14th August 2020

Reference Planning Application No. 3/2020/0567 re. land off Shire Lane
Hurst Green.

PROPOSED PLANS AND ELEVATIONS

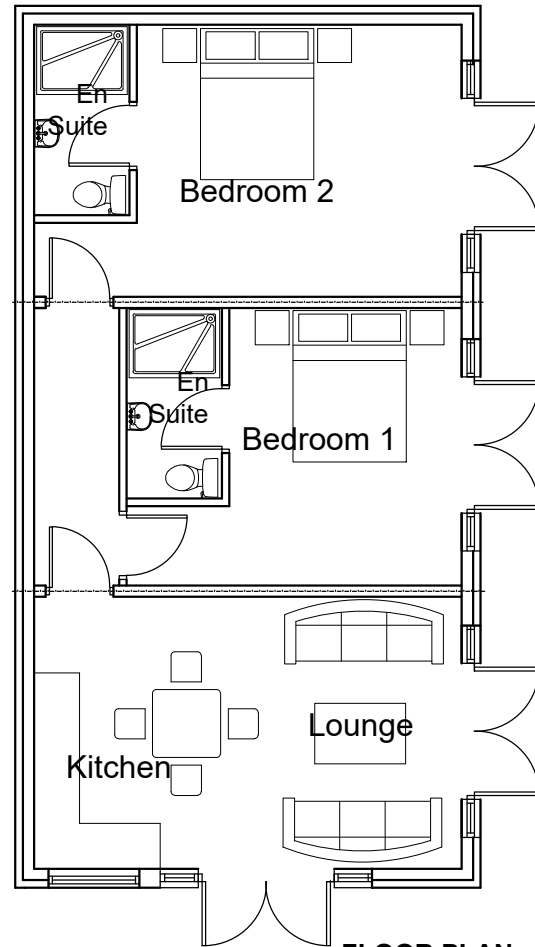
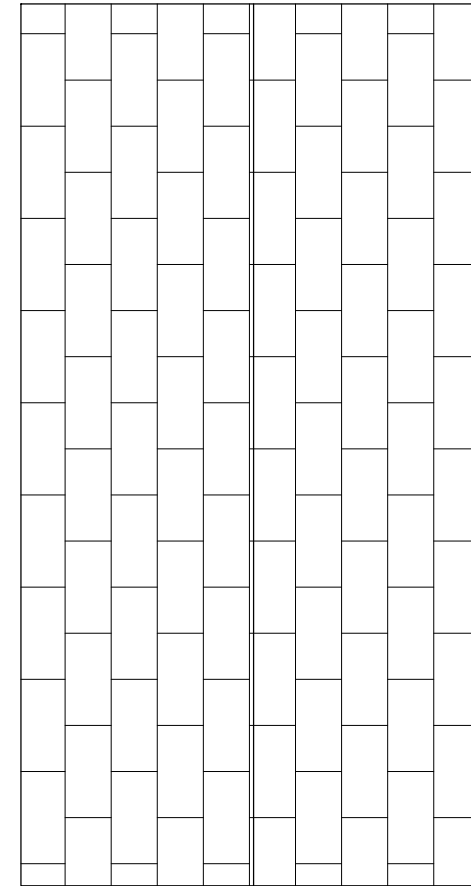
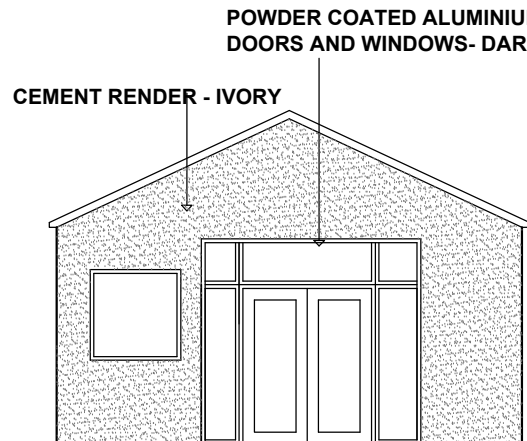
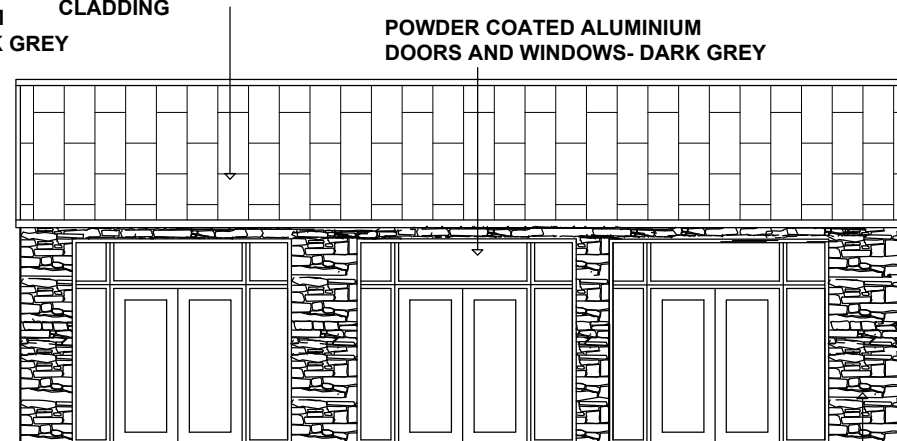
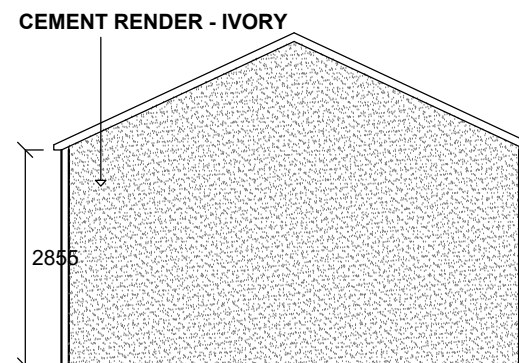
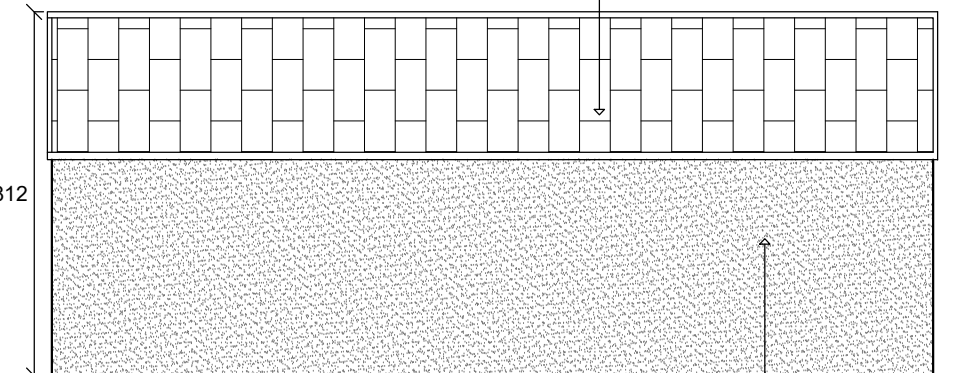
In principle, I have no objection to the building of a single dwelling on this
site subject to it's design, materials and construction being in keeping with
existing houses on the lane. Plan No. 2 of the application shows details
which I feel fall short of acceptable standards.
